## Planning &amp; Urban Development Department

TO: Zoning Board of Appeals Chair and Members

SUBJECT: 49 Hancock Street – 020-B-013

DATE: March 11, 2015

# DETAIL OF 2ND FLOOR

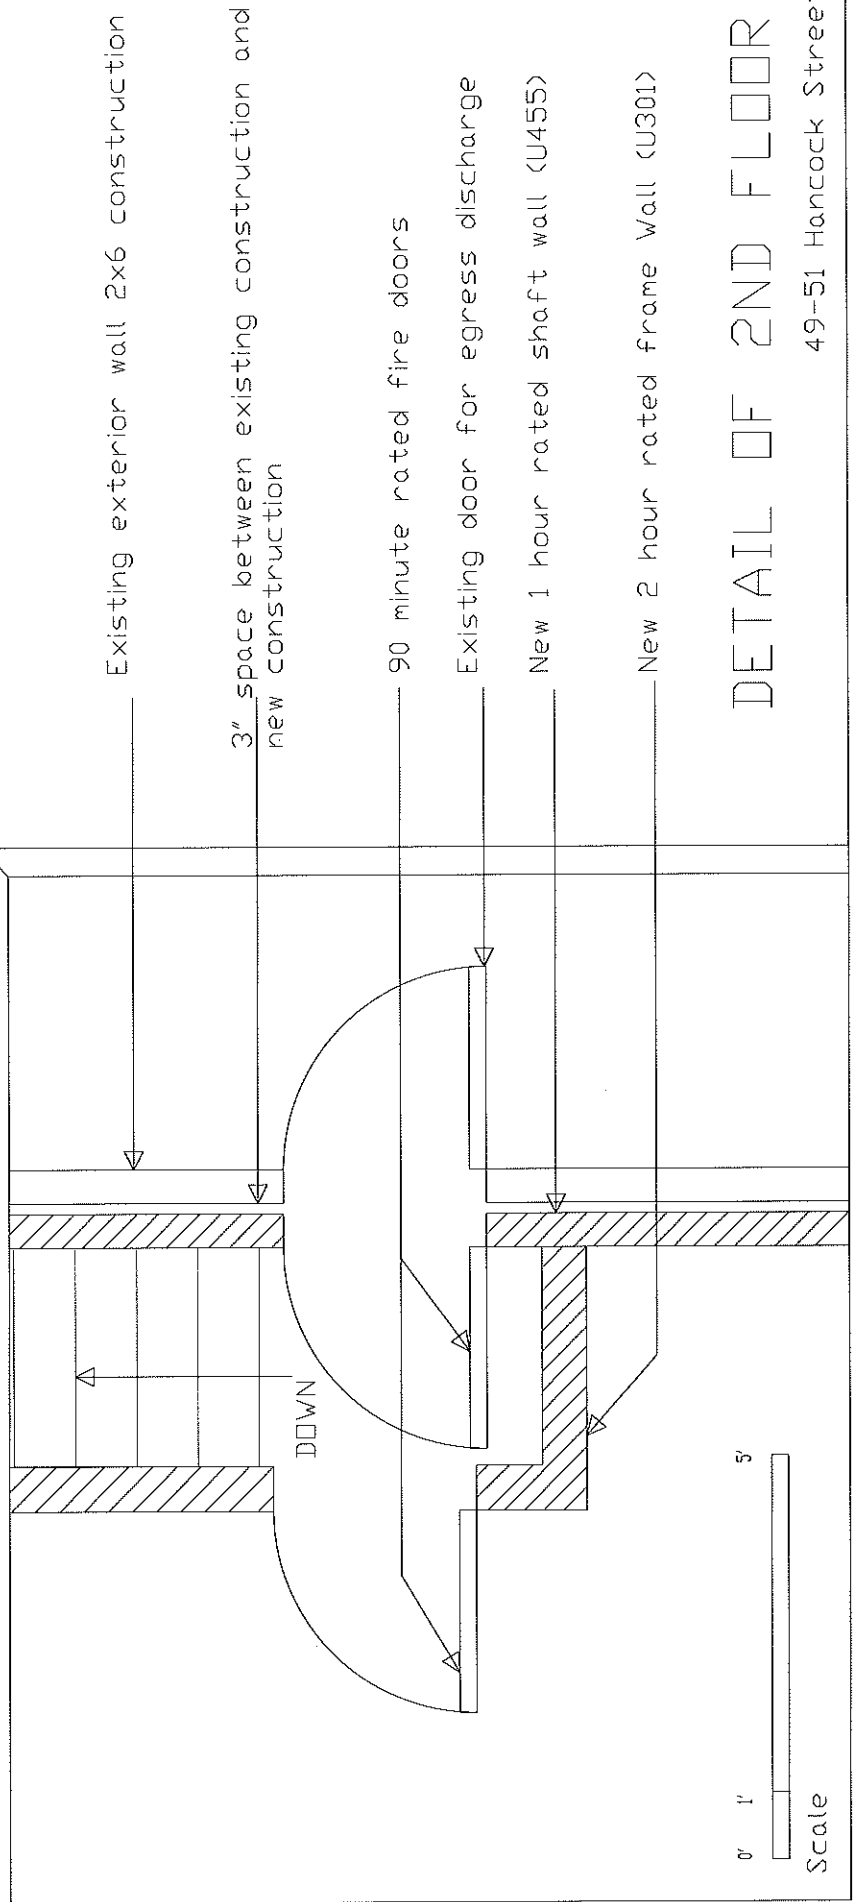
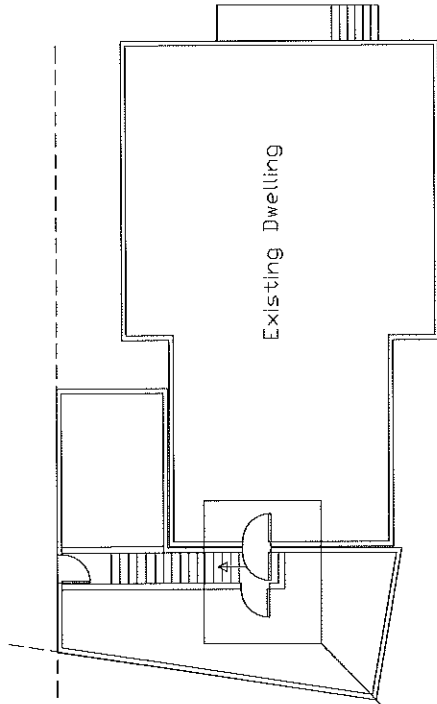
Accessory structures are not specifically defined in the Land Use Ordinance. As I told Ms. Chase in an email dated February 6, 2015, when a term is not specifically defined, it is the practice to look at other sources for the definition. For zoning terms, I turn to books that are published or compiled by Planning Associations. For instance, I use A Glossary of Zoning, Development and Planning Terms (Exhibit B) which uses definitions from municipalities around the country. Exhibit C gives the definition of an accessory structure. It defines it as a subordinate, detached structure. It goes on to give some examples of accessory structures such as a garage, deck or fence. The key word here is that an accessory structure is detached. Ms. Chase states that the proposed structure has a separate foundation, walls and roof. This may be the case, but the two structures are touching and there is a doorway that connects the interior of both structures on the second floor providing direct access between the two. Since one can go from one building to the other within the enclosed area, the buildings are attached and therefore the proposed structure is not accessory structure.

As Ms. Chase points out, section 14-47 of the ordinance does define "Principal Building". It defines it as, "The building occupied by the chief or principal use on the premises. When a garage is attached to the principal building in a substantial manner as by a roof or common wall, it shall be considered as a part of the principal building". This definition does not say that being attached in a substantial manner is only by a roof or common wall. These are just examples. The fact that there is a doorway that connects the interior of both structures and provides direct access between the two on the second floor is also an example of being attached in a substantial manner.

In conclusion, the Zoning Division is not denying Ms. Chase the right to build a structure that includes a garage and storage. The Zoning Division is saying that the structure as proposed in Permit #2015-00151 is attached, and therefore has to meet the ten foot rear setback as required in Section 14-185.
